KITTITAS COUNTY COMMUNITY DEVELOPMENT SERVICES

Subject: Wenger (SPF-18-00005) Final Short Plat – Staff Review and Request for Additional Information

RE: Wenger Short Plat – Final Plat (SP-07-00007)

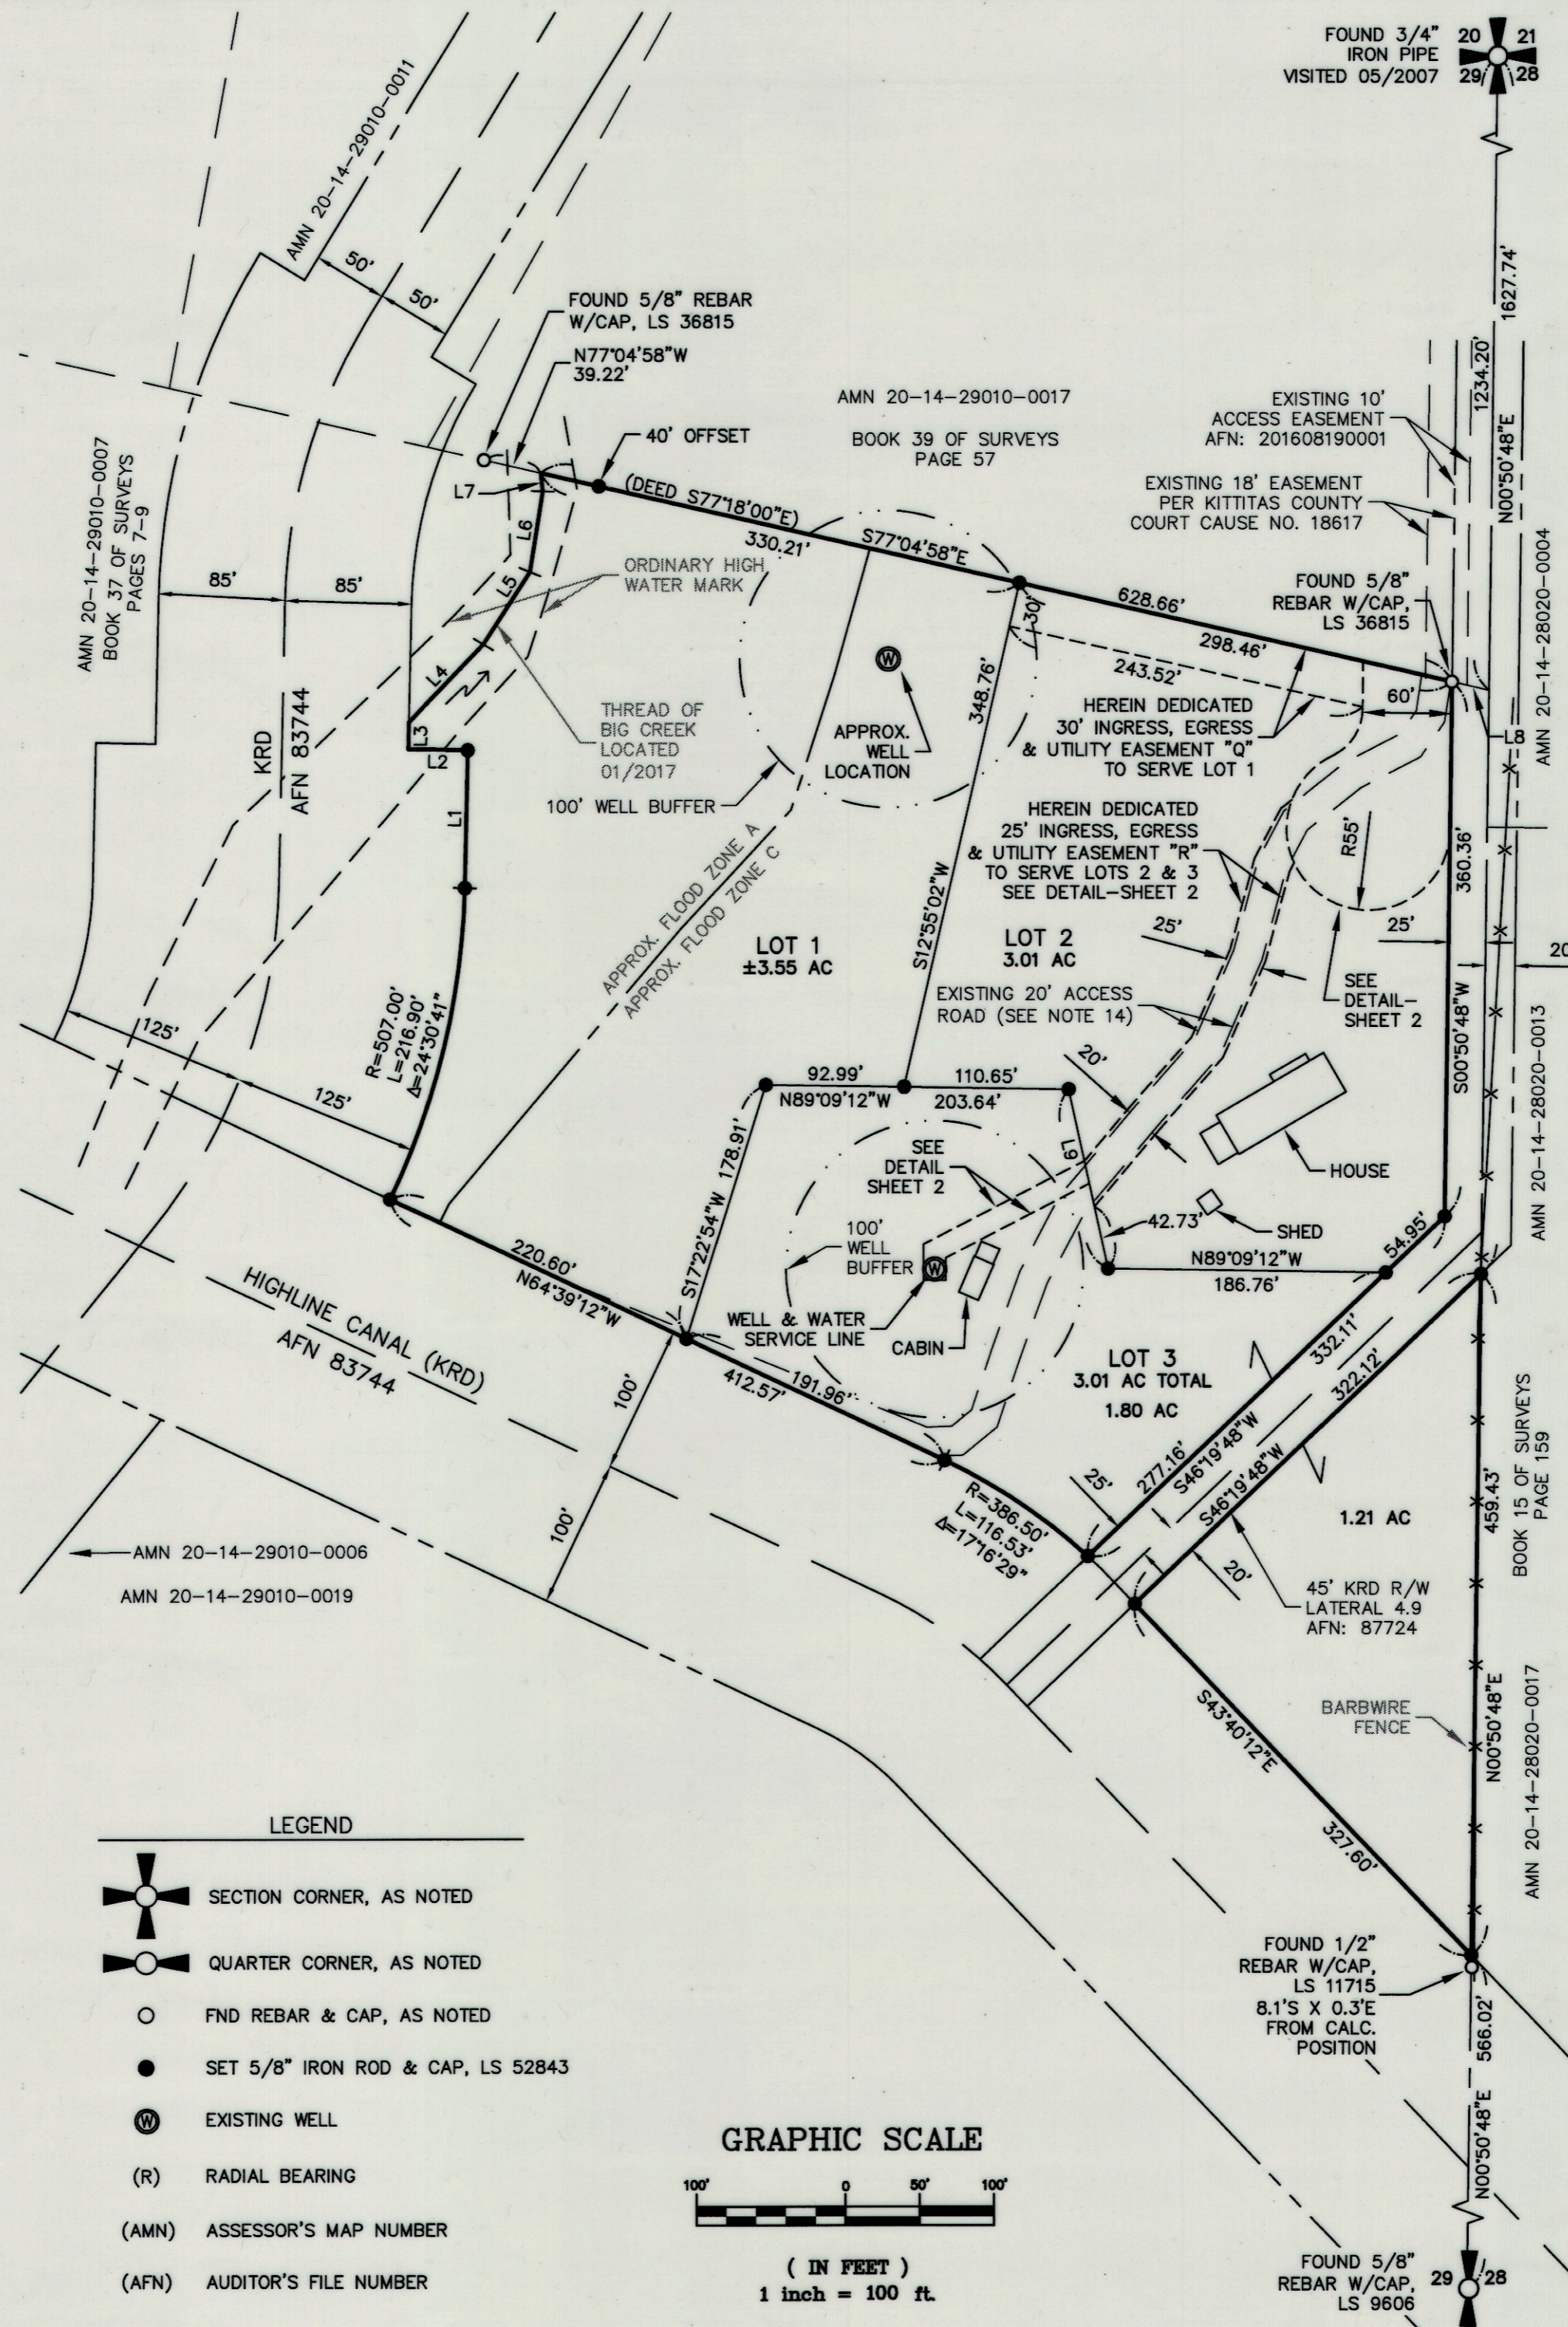
The submitted final short plat depicts the ordinary high watermark of Big Creek, but does not show the full 200' shorelines jurisdiction as requested nor does the final short plat depict the easement and driveway serving parcel 616536. Please revise the plat to depict the full shoreline jurisdiction and the easement and driveway serving parcel 616536.

1. Please see attached memo dated September 24, 2018. The materials submitted do not address this requirement to the satisfaction of Public Works. The following items must be addressed:
 - a. The easement as shown on the plat does not depict the full access to parcel number 616536.
 - b. Please provide a private road certification of the road serving the plat.
 - c. Provide either 1) an access agreement from the Bureau of Reclamation with a term of at least 50 years, or 2) provide evidence that a longer agreement period cannot be obtained from Bureau of Reclamation.

3. Preliminary condition of approval 7(d)(v) requires the access to parcel 616536 be shown on the final plat. That condition is not met on the final plat that I have been provided for review.
